Application No: K/12/22/HH
Site Address: Meadow House Kingston Lane Kingston BN16 1RS
Description of works: Erection of single storey rear and front porch extension, erection of self contained detached annex and alterations to fenestration.

Thank you for your internet representation made on 20th May 2022 which has been recorded as an objection with the comments as follows:

Drawing Title: Proposed detached annex building

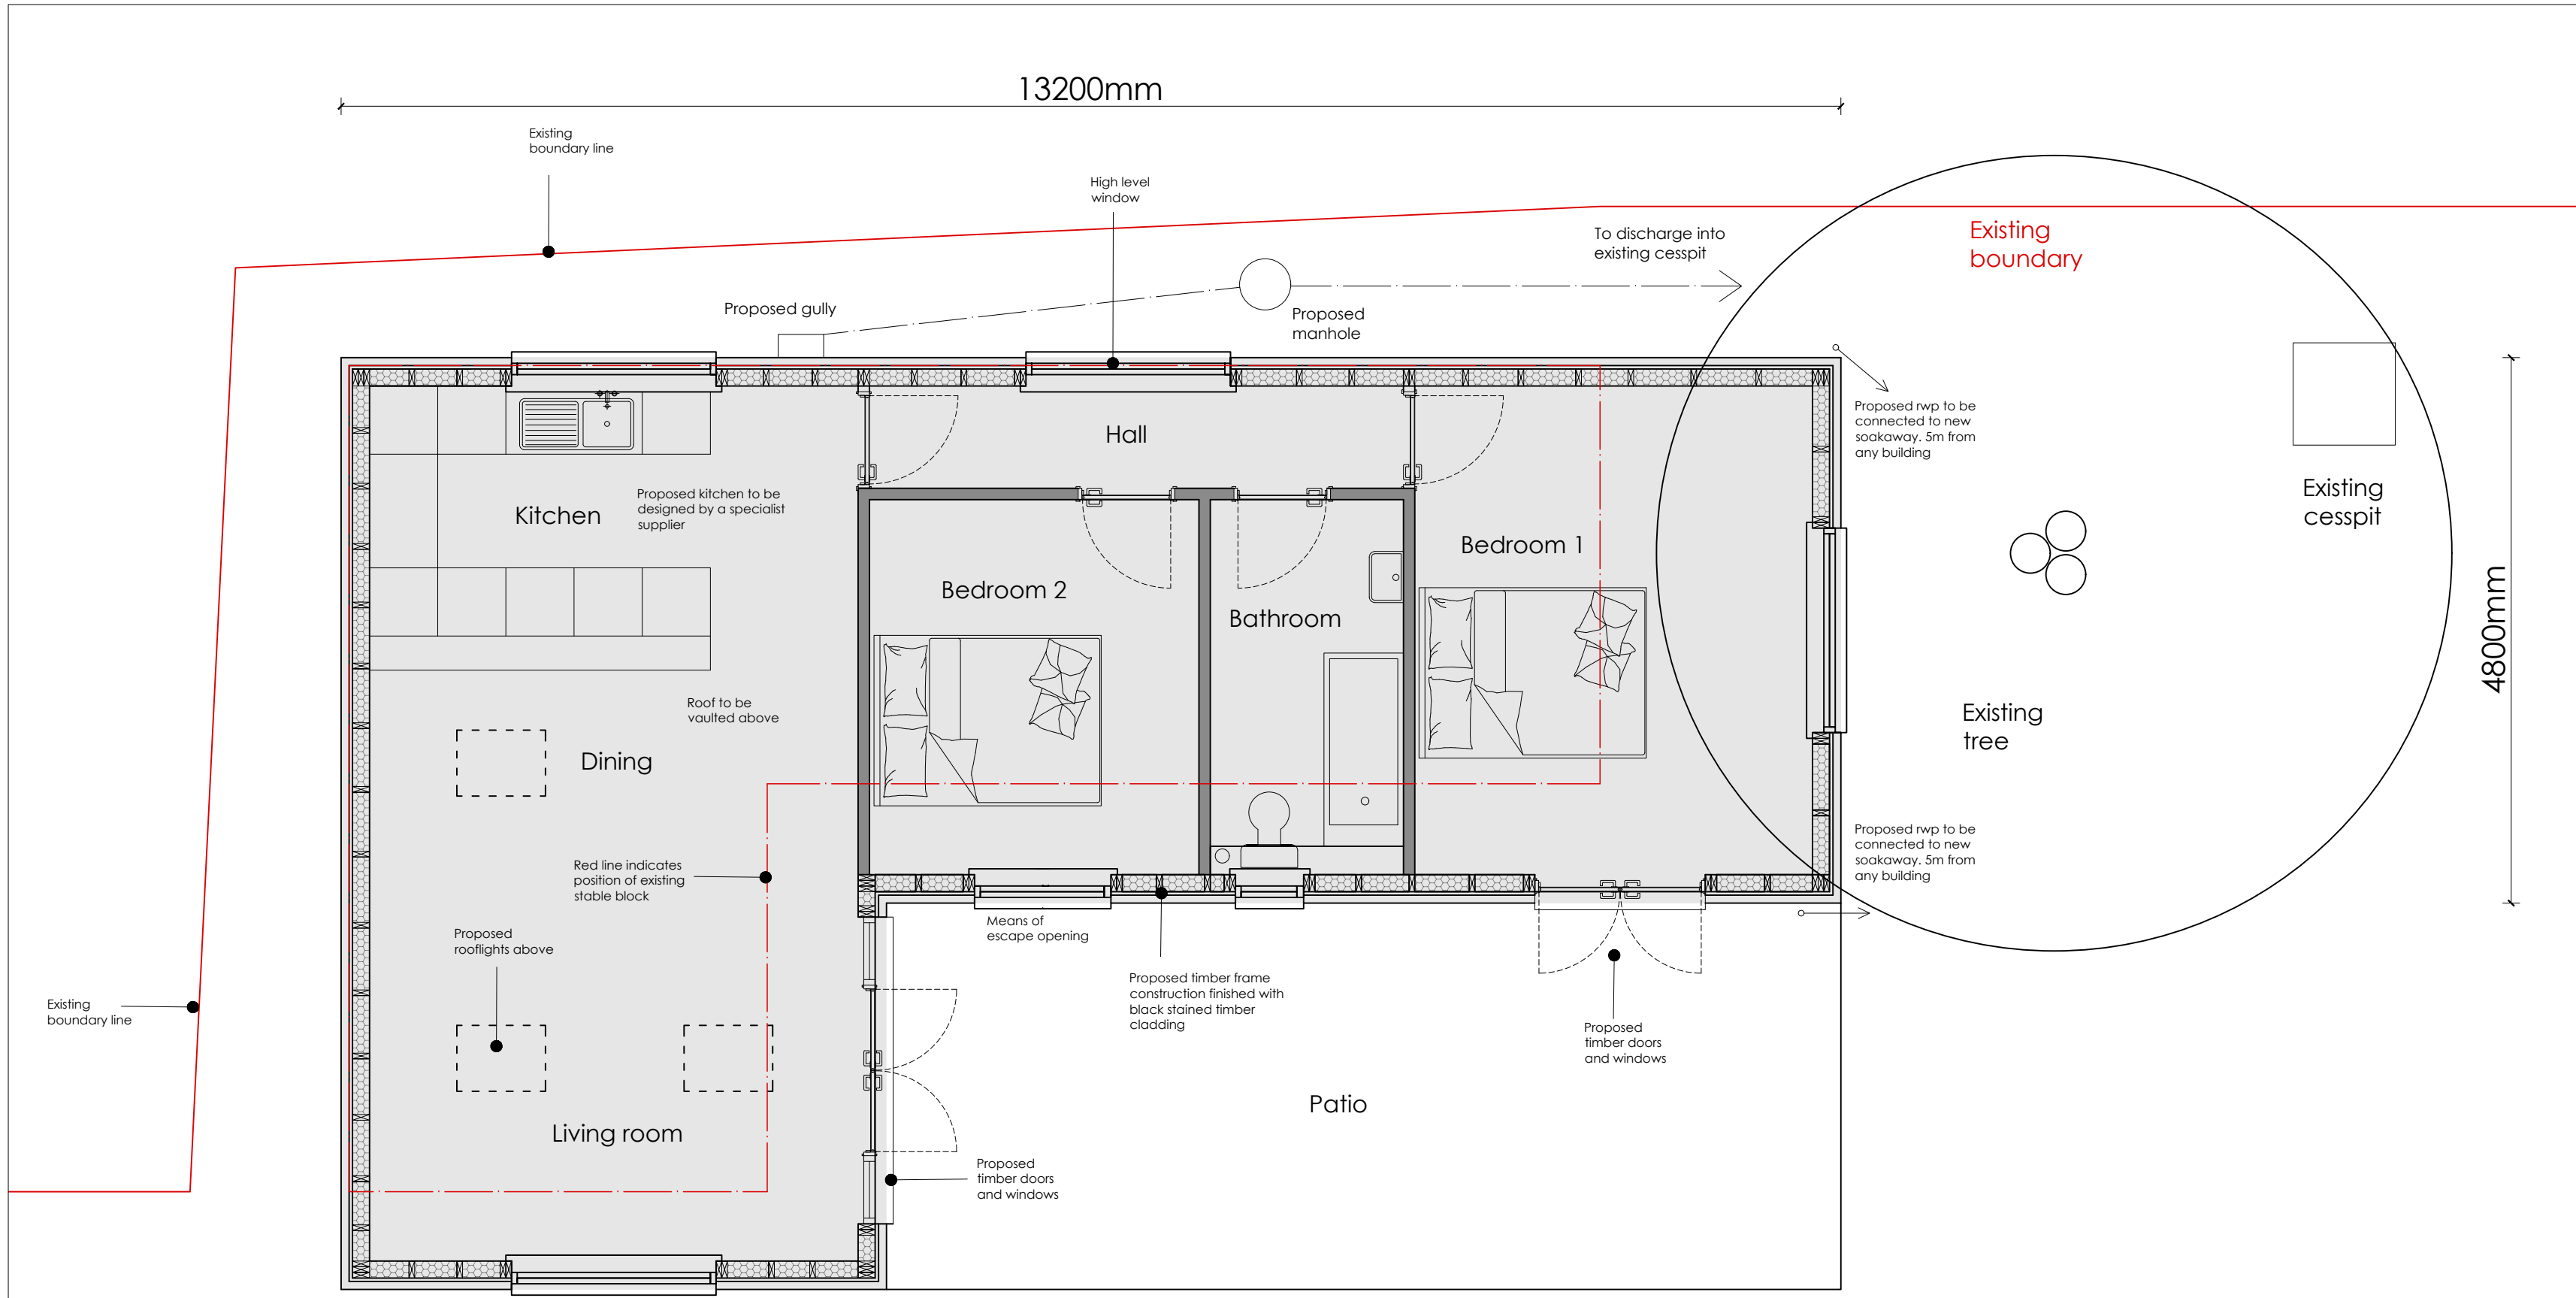
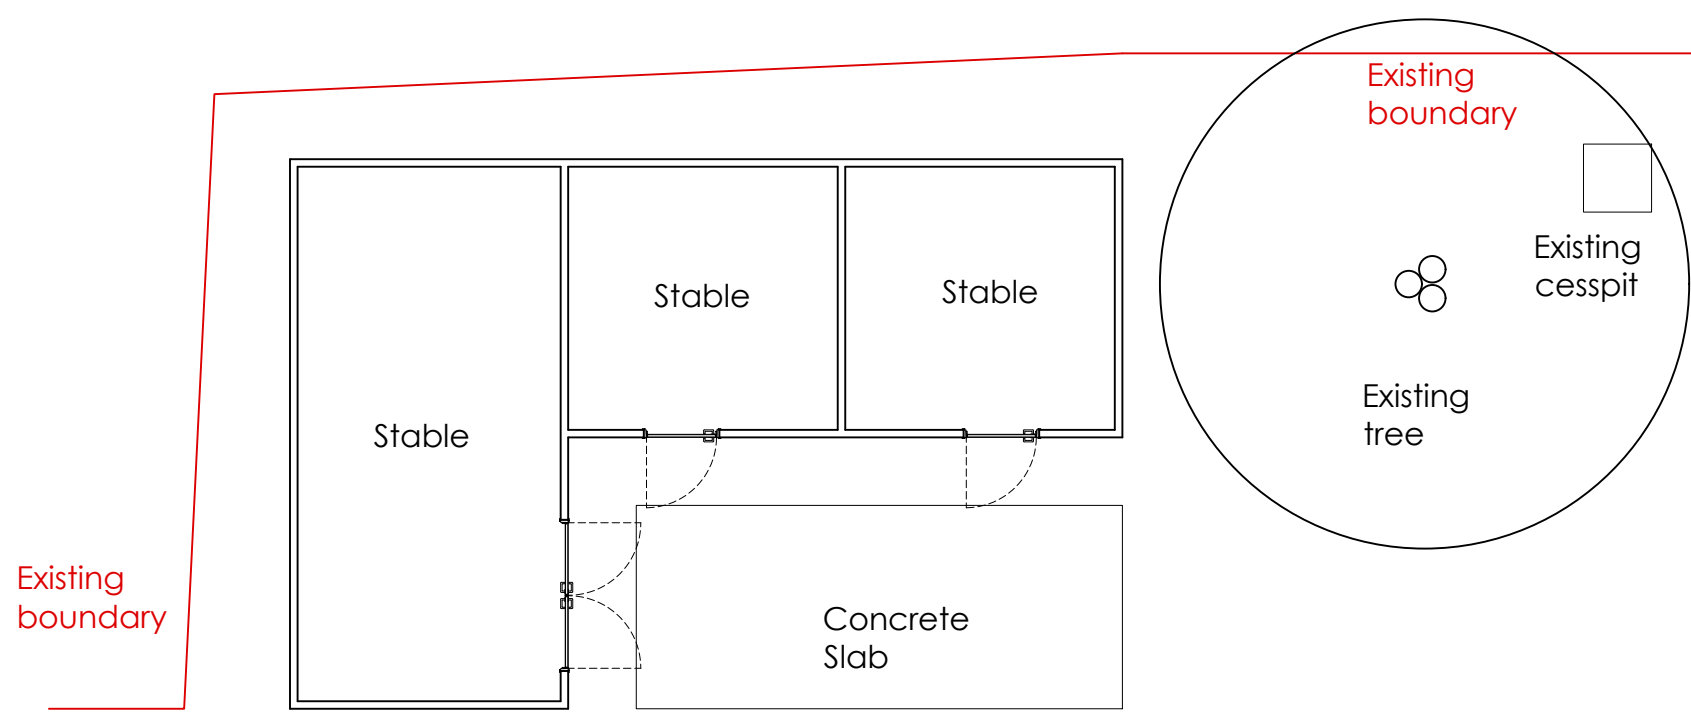
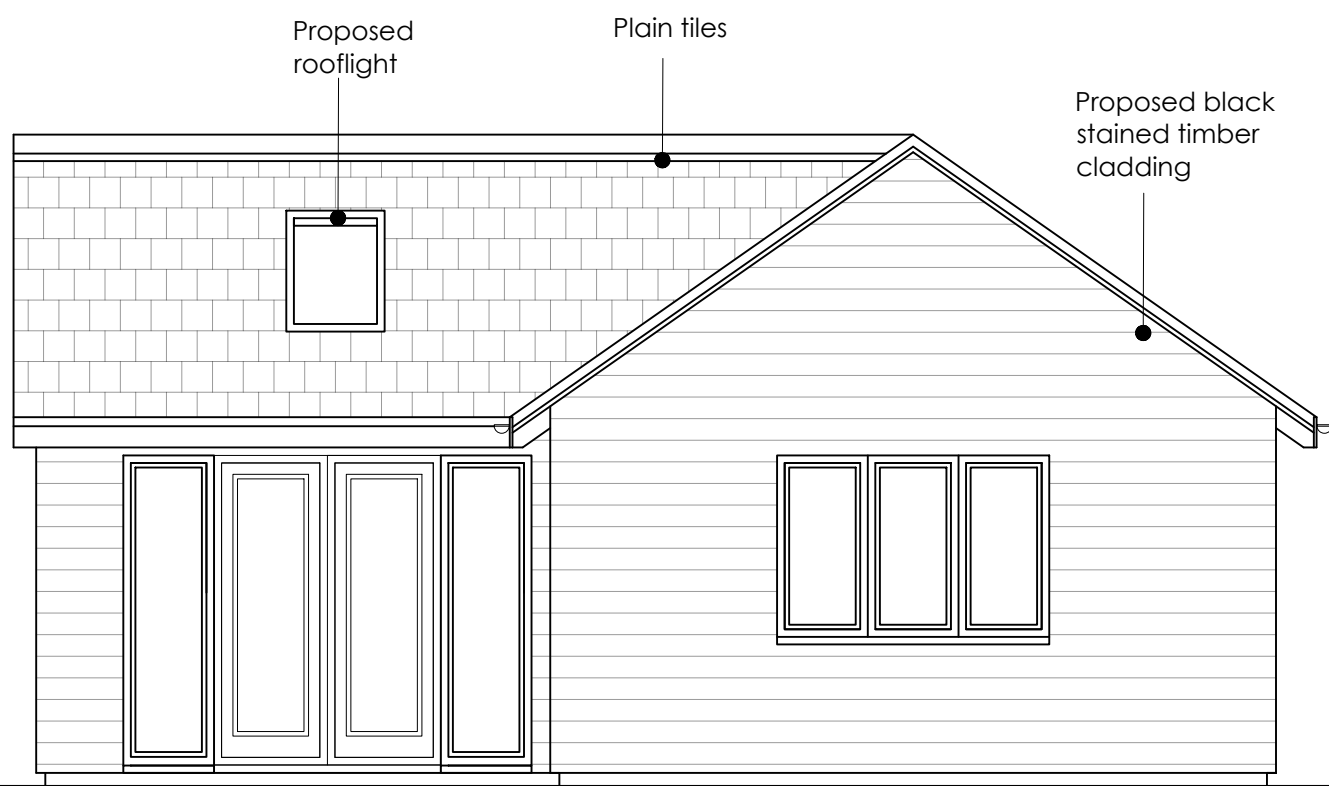
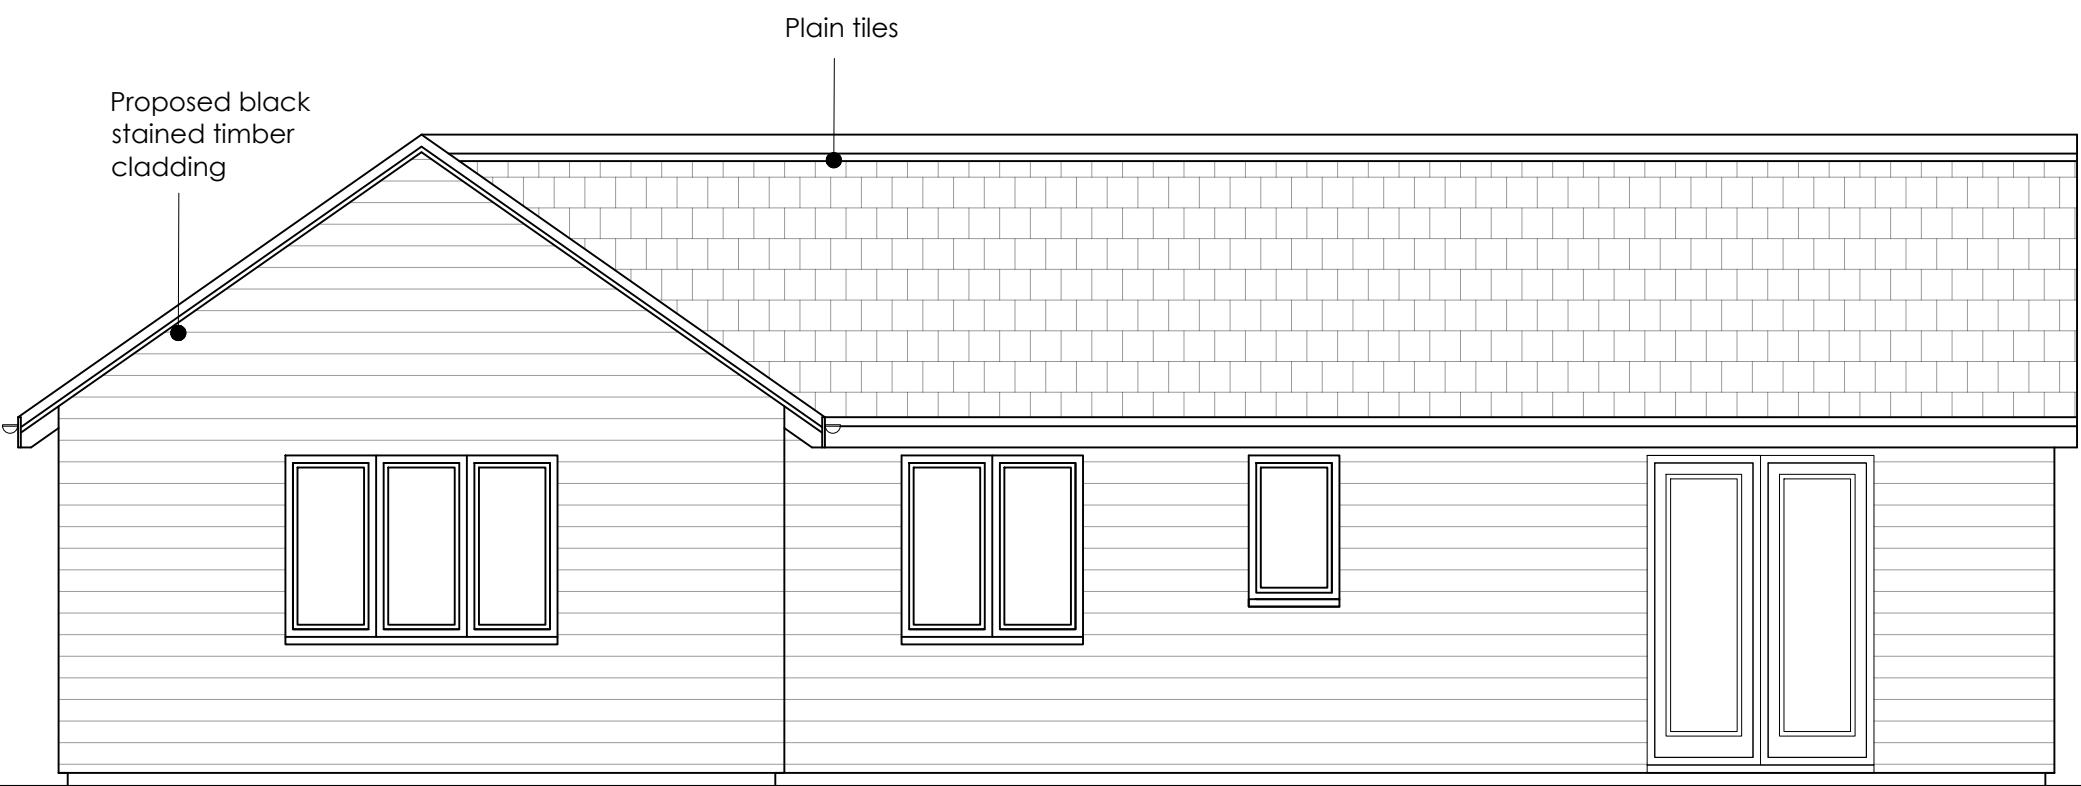
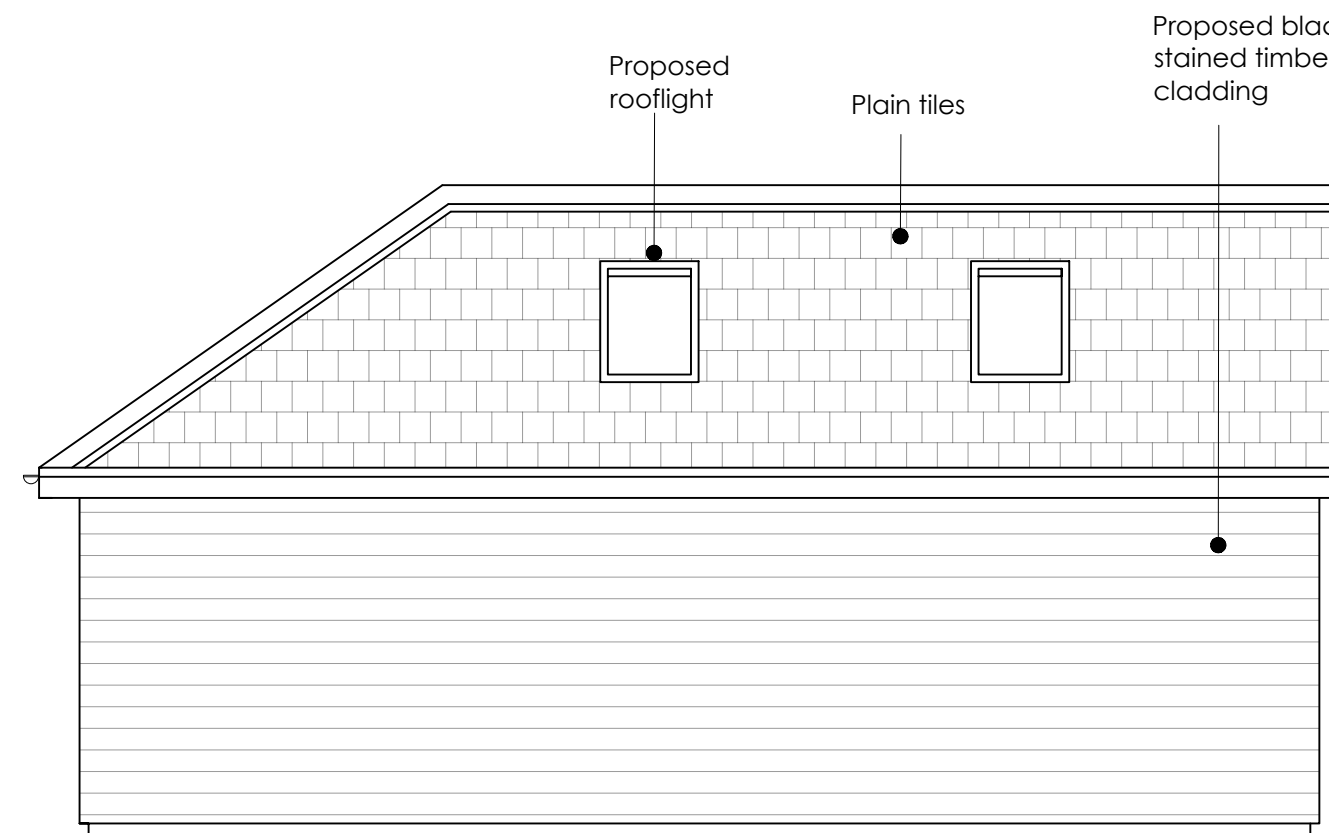
- Council does object to the creation of a self contained annexe by the conversion of a stable block

1. The stable block was approved in 1984 (planning application K/12/84) and is for equine use. This proposal represents a change of use on a site that is outside of the built up area boundary and in the Gap between Settlements that is predominantly agricultural countryside.

4. The stables are built on a 'dink' into the neighbouring field that is used for grazing horses and residential use could impact on this.

5. Council considers that the proposed annexe is too far from and detached from the main residence to be considered subservient to or ancillary to the main dwelling. It would be a separate dwelling.

7. Windows to the east elevation could overlook and would be in close proximity to the neighbouring field used for grazing. Windows should be obscure glass or with a condition that suitable screening fencing be installed in perpetuity.
